## **Planning Application No. 12/0241 - Chatburn Village Motor Company**

Chatburn Parish Council has viewed the amended proposals to Planning Application No. 11/0306 and has the following observations to make:

Plot 344 Elevations

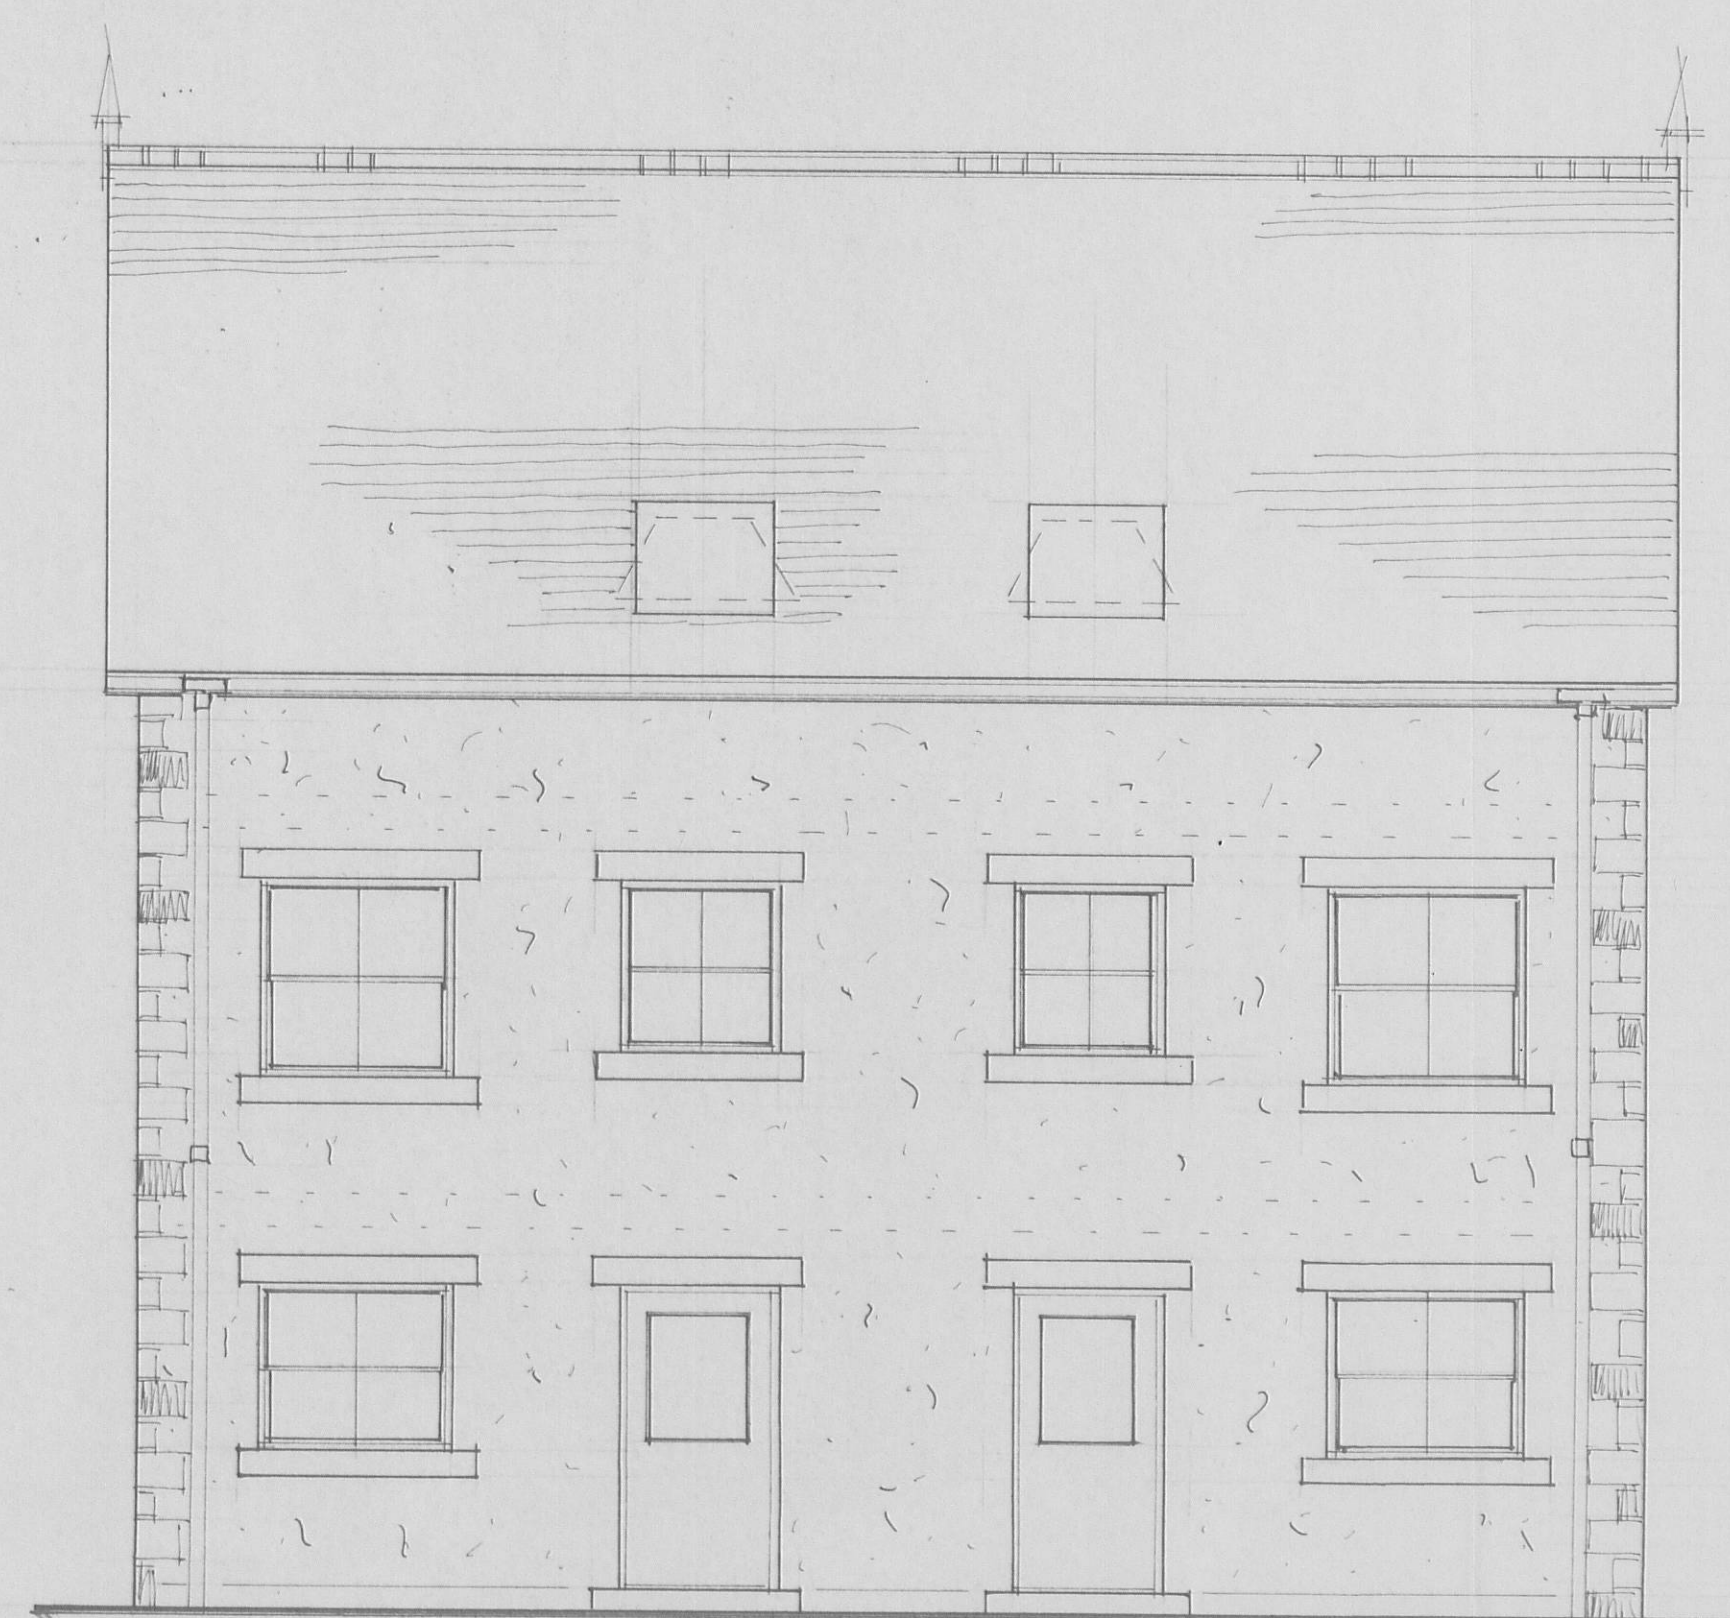
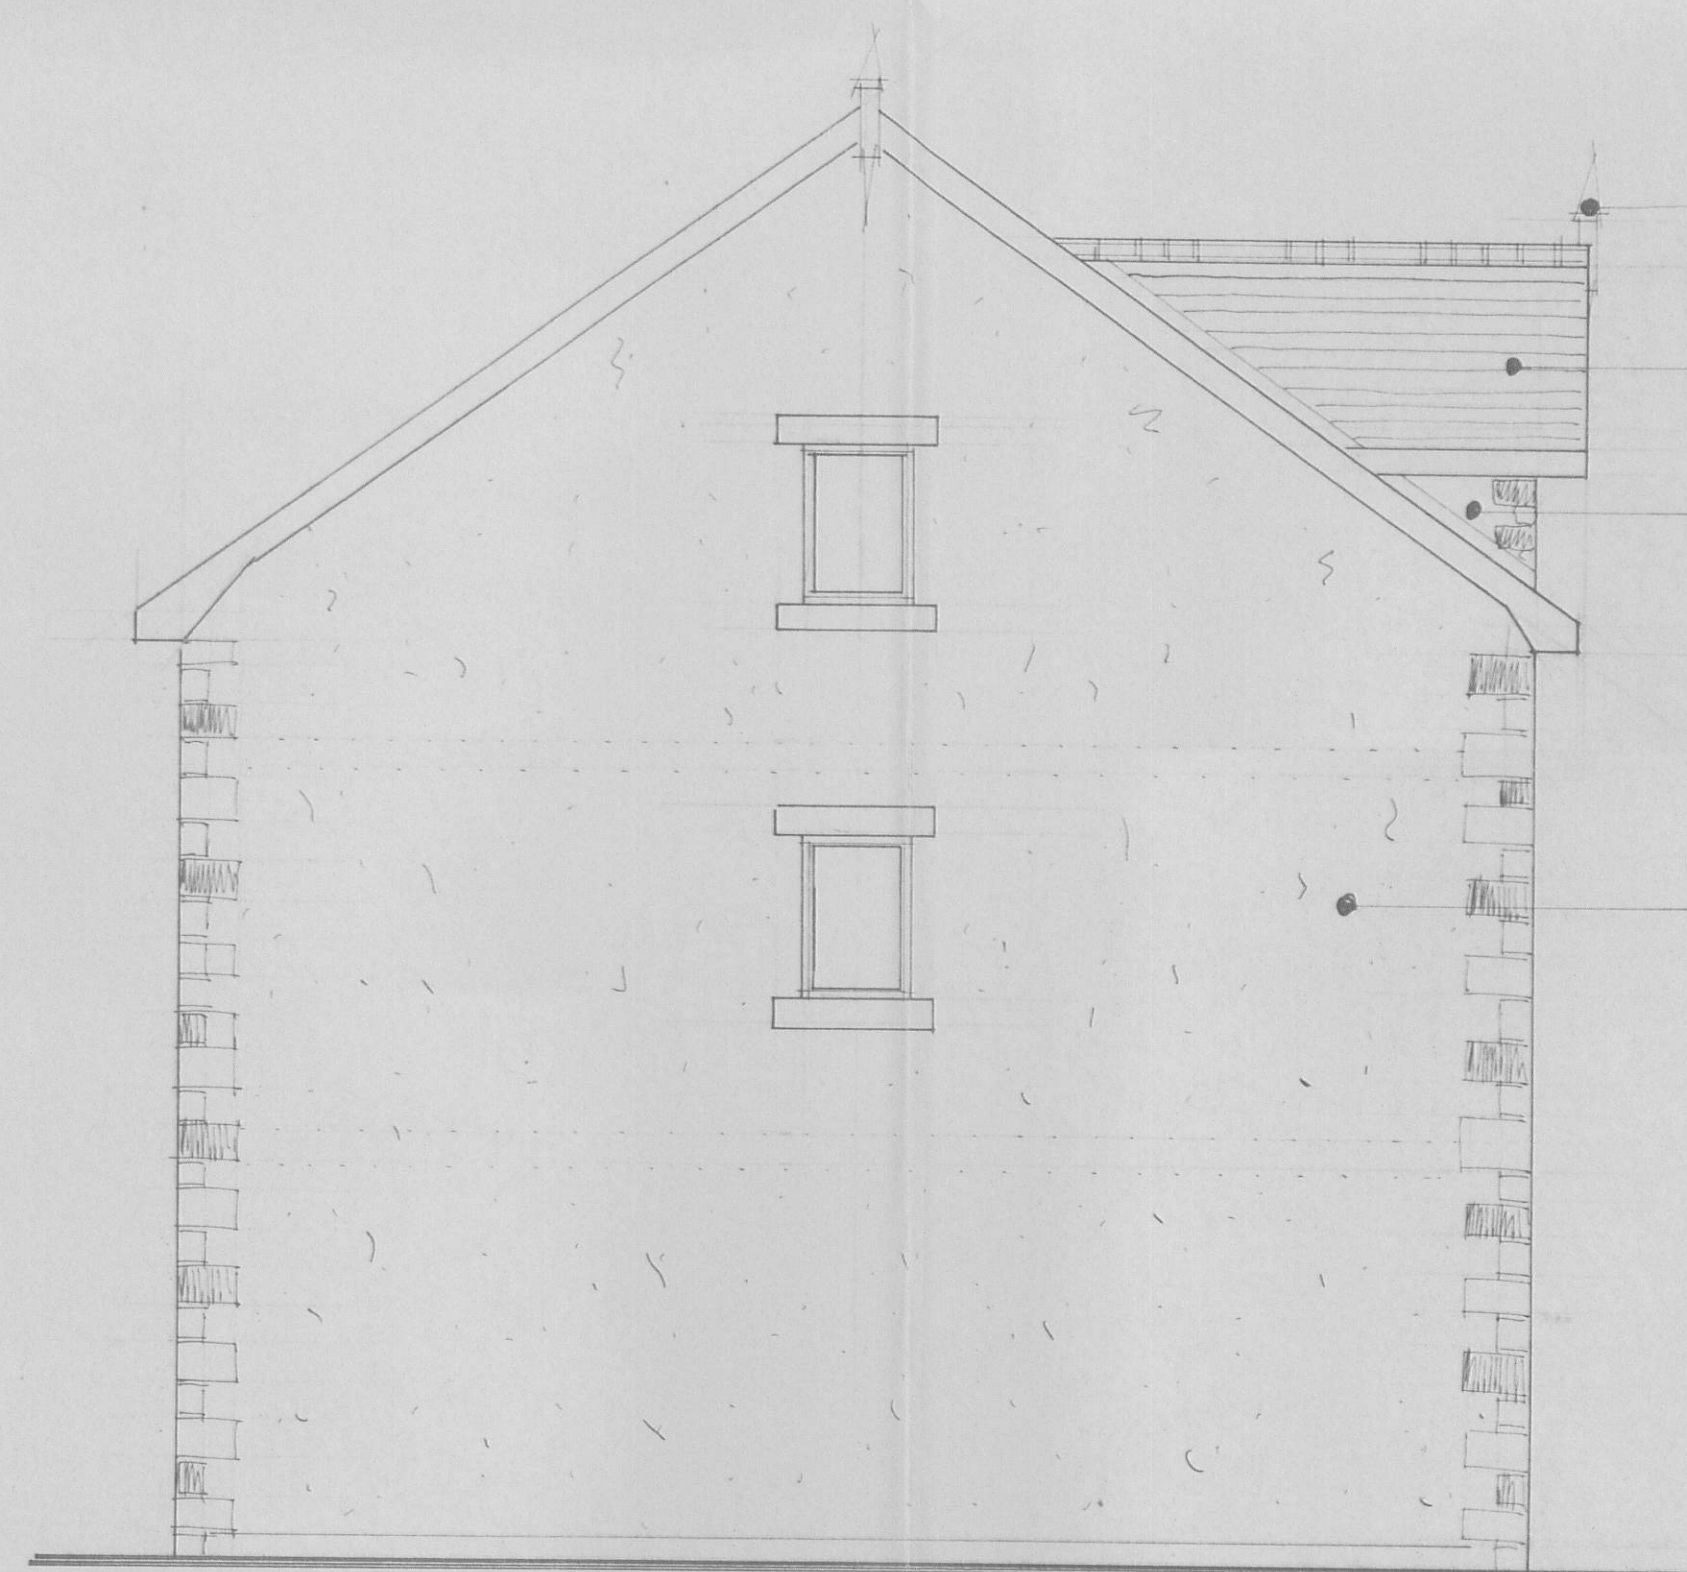
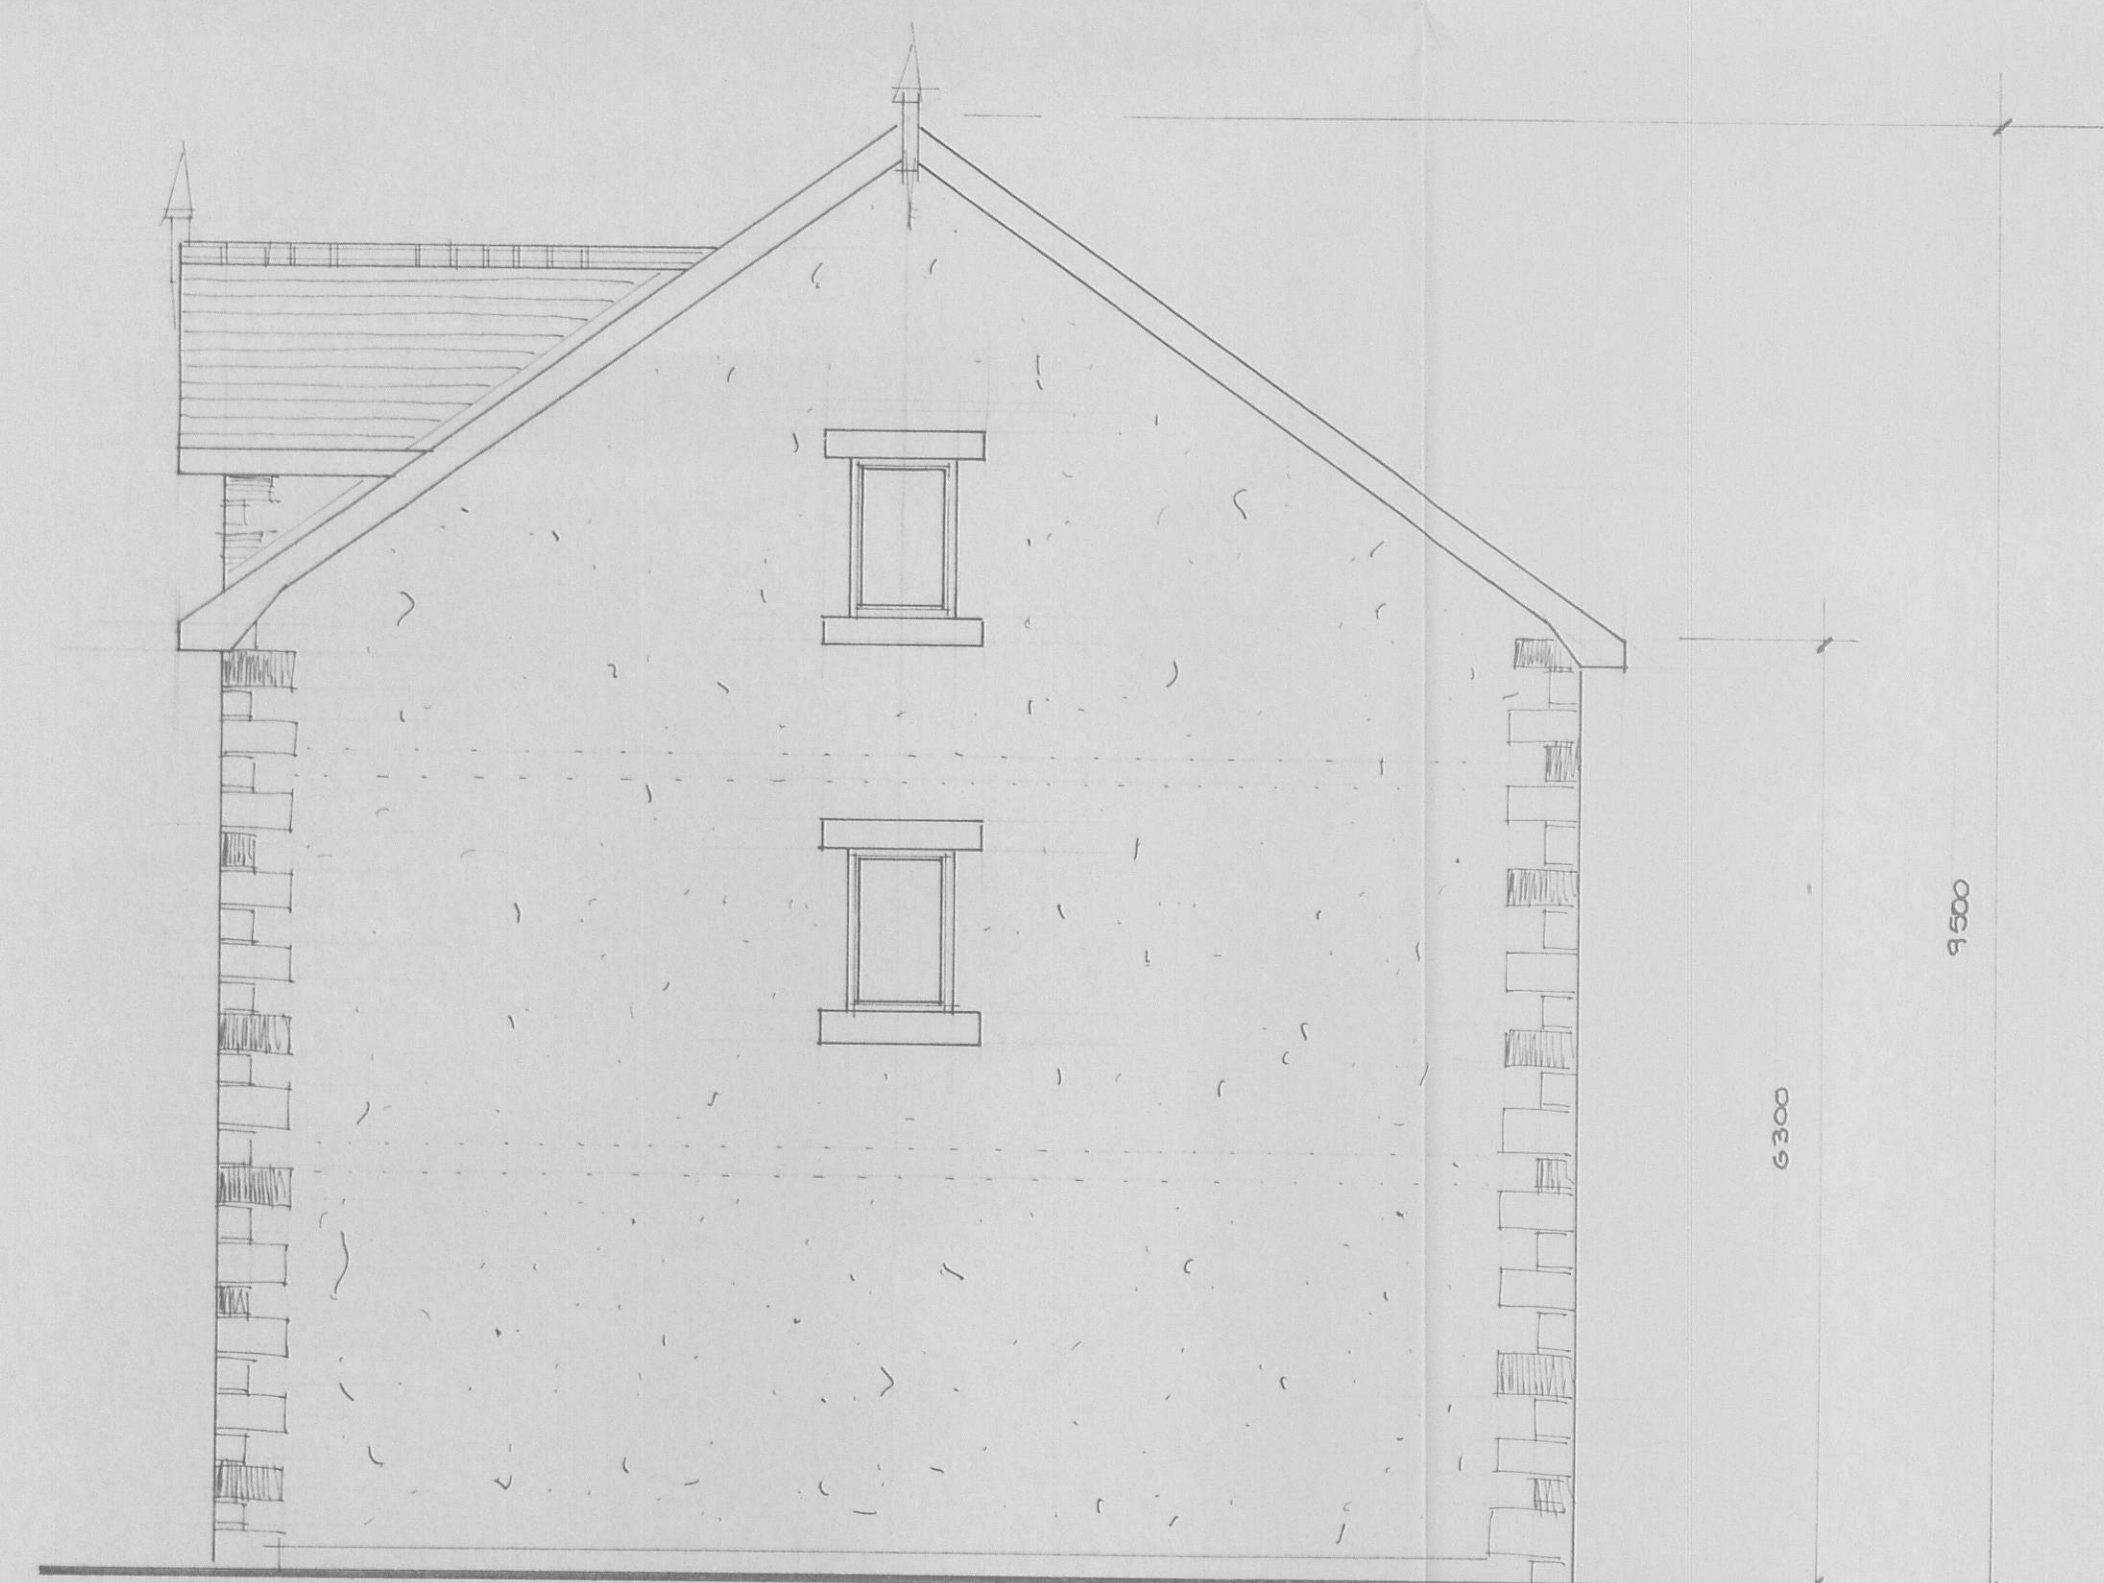
- The site location incorrectly states that there is a public car park opposite the application site, this car park is owned by Christ Church.
- It is recommended that the windows on the end of the terrace should be opaque
- There is still concern that the ridge heights of the proposed development are higher than the properties on Sawley Road
